1 October 2024

PLANNING APPLICATION NO 2024/N/92539/E - Prior notification for erection of agricultural building at land off, Church Lane, Birstall, Batley, WF17 9NX.

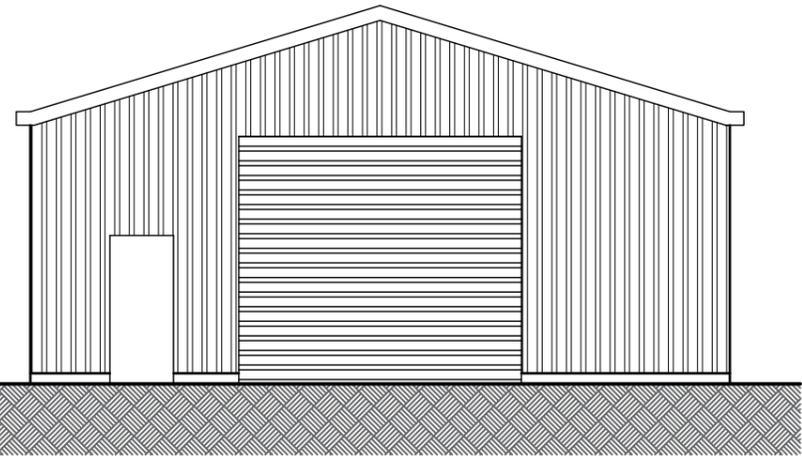
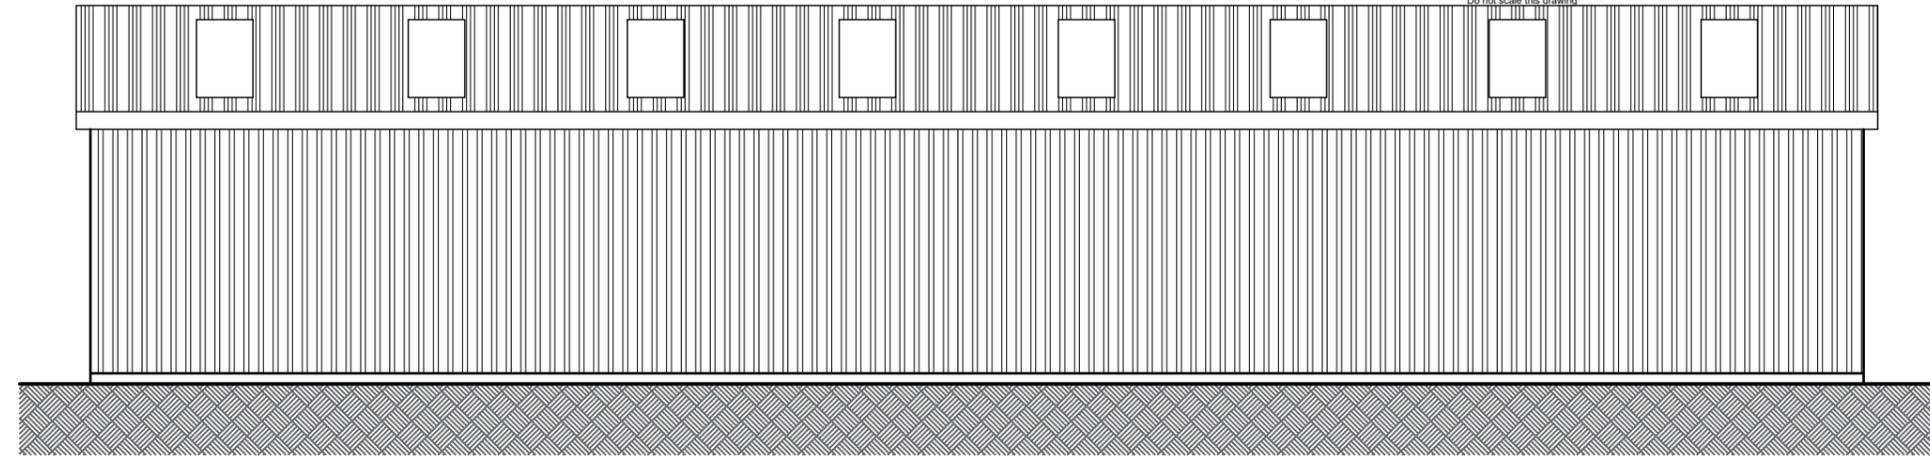
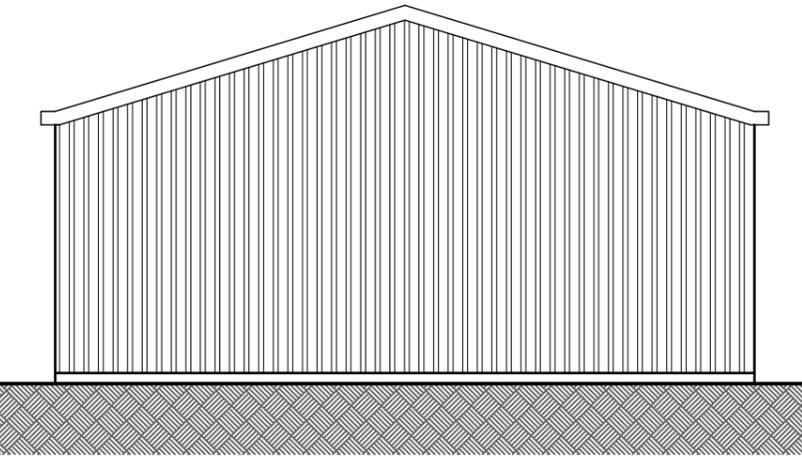
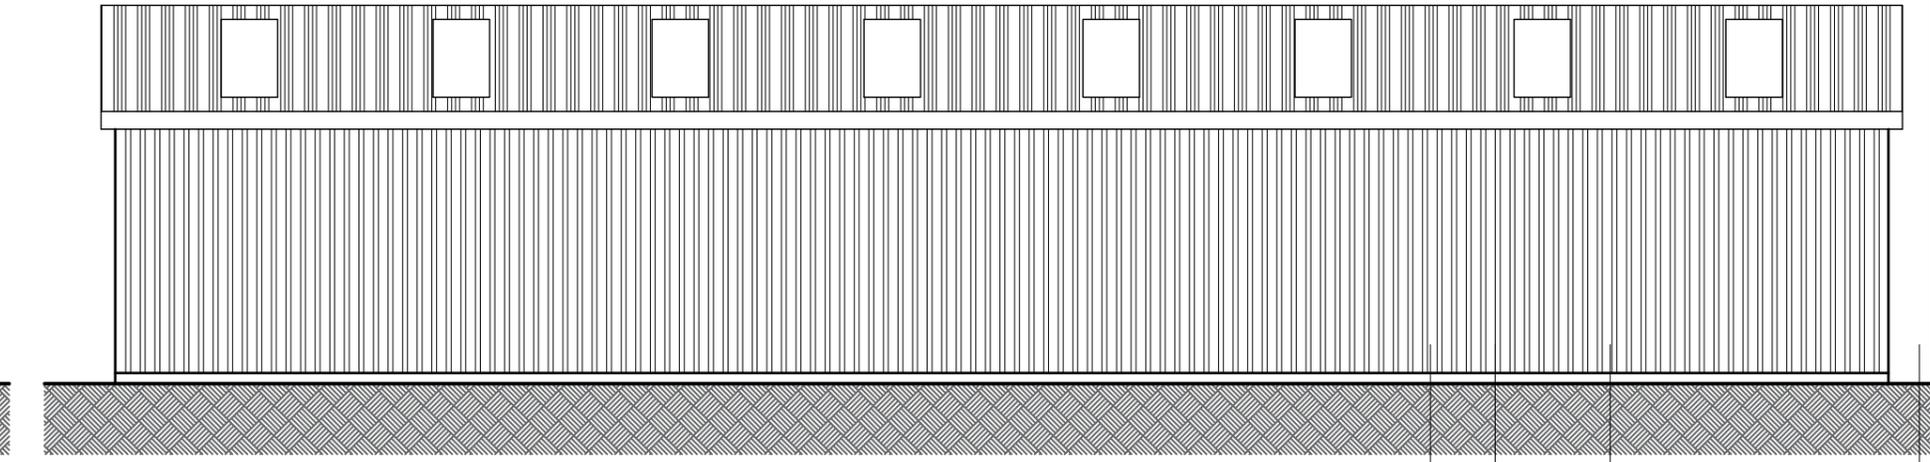
- d) the design and materials should have regard to relevant design policies to ensure that the resultant development does not materially detract from its Green Belt setting **the proposed materials are not in accordance with the relevant design policies and largely consist with that of an industrial development**
